Please ask for: Nicola Moore
Email: nicola.moore@arun.gov.uk
Telephone: Ext 37944
Our Ref: AB/19/22/HH
Your Ref:
Date: 3rd March 2022

Application for Planning Permission for Works or Extension to a Dwelling

Development: Proposed side extension, loft conversion, changes to external finishes, together with internal alterations and all associated drainage works
Location: 39 Priory Road Arundel BN18 9ET

NOTES

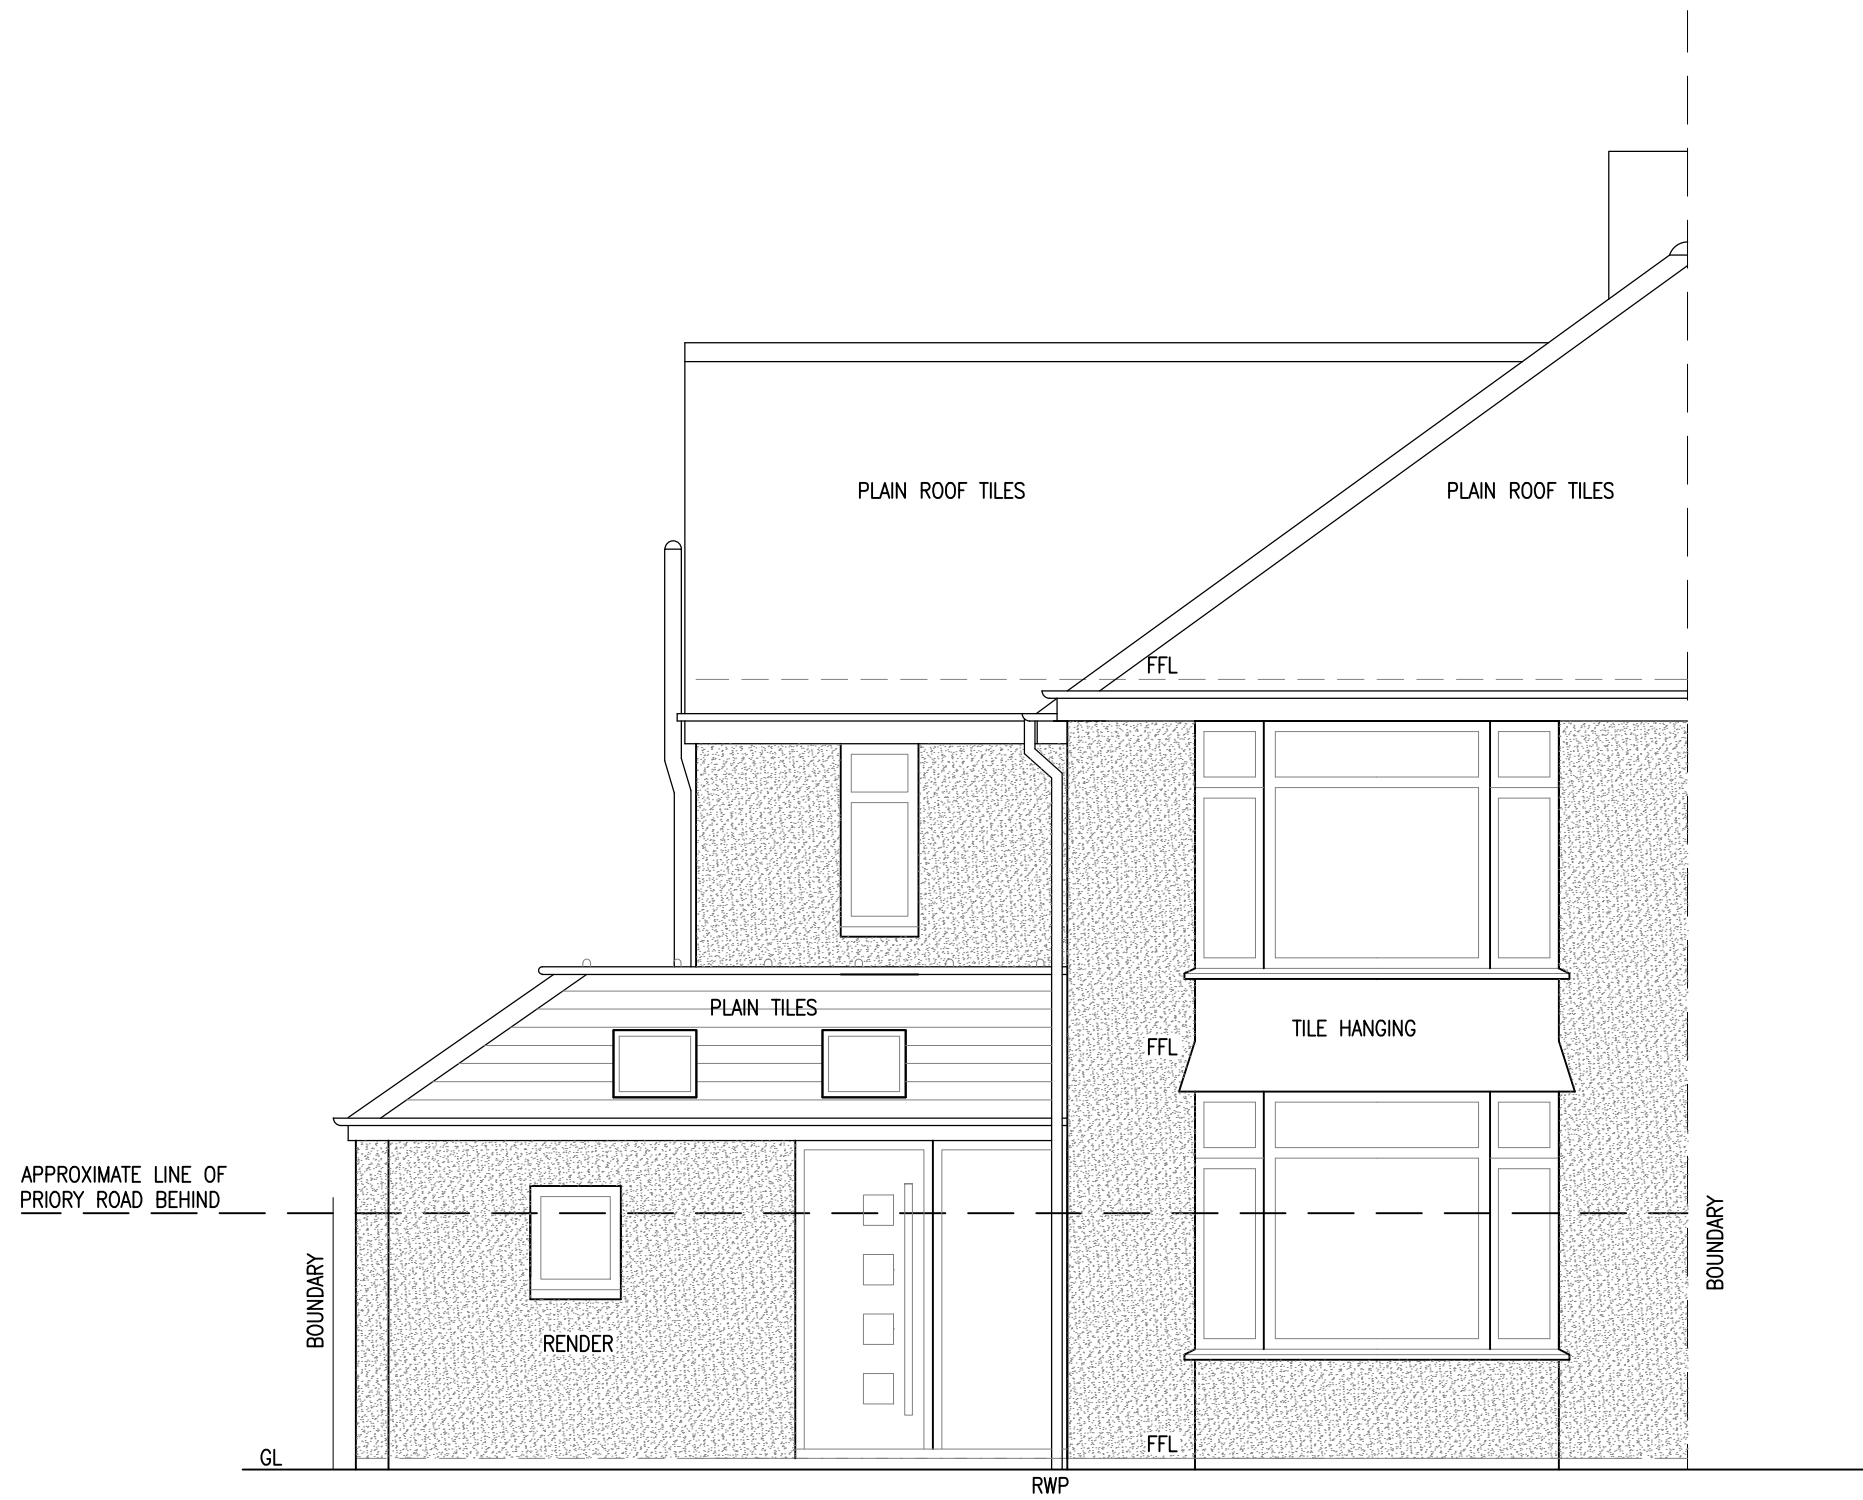
Dwg No 2.03 Rev A is titled Elevations and Section as Proposed, but the each elevation/section is titled existing. Please amend accordingly and re submit.

LOFT PLAN / ROOF PLAN
AS EXISTING
1:50

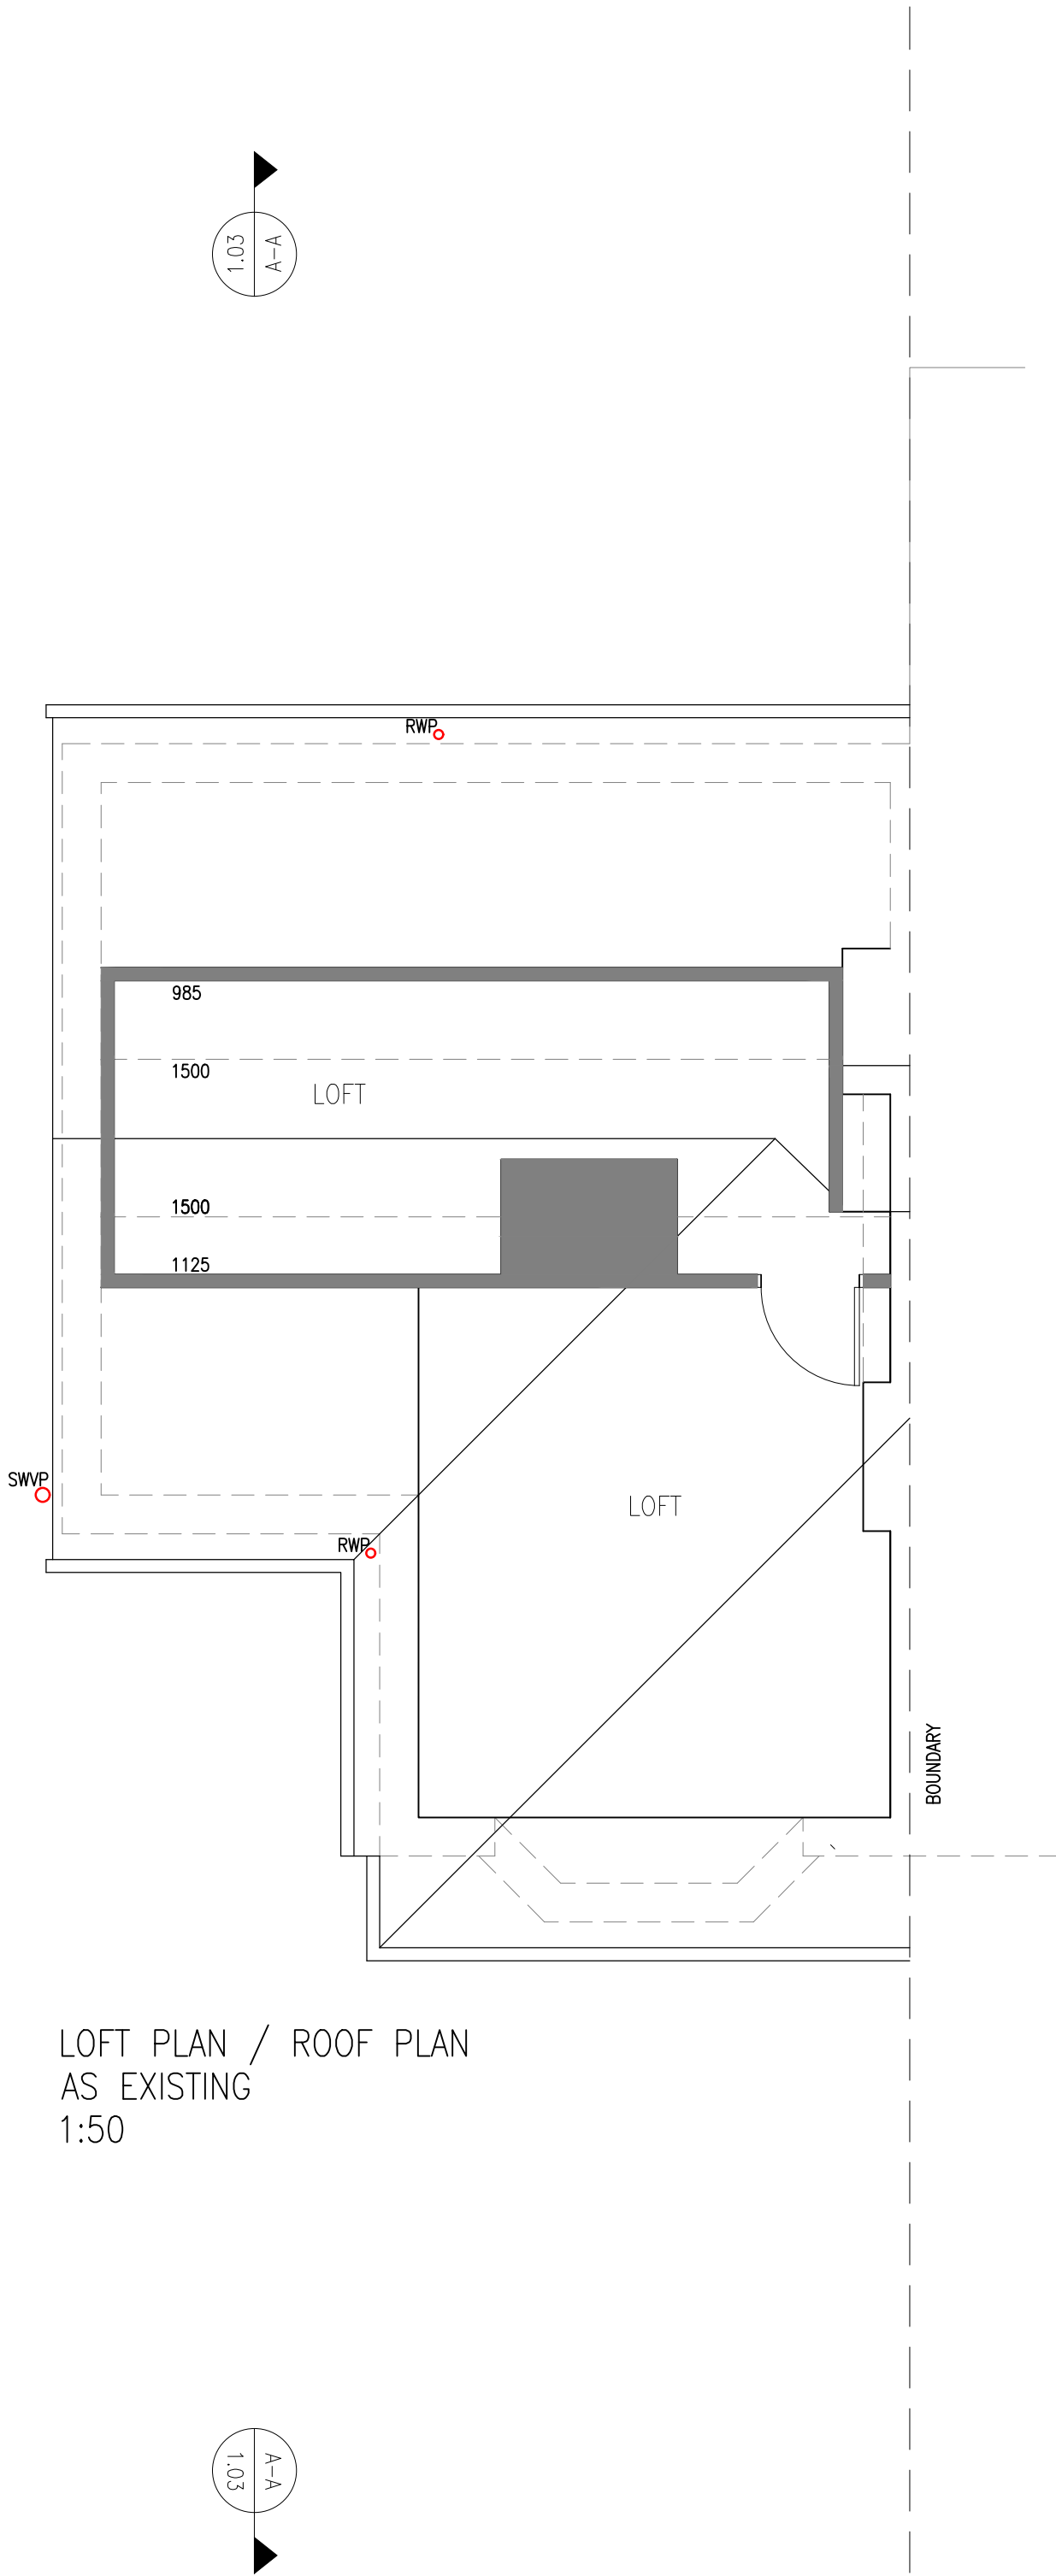
Roof Plan

Please submit electronic plans showing the existing and proposed roof plan. Please refer to the Validation Requirements List for further details.
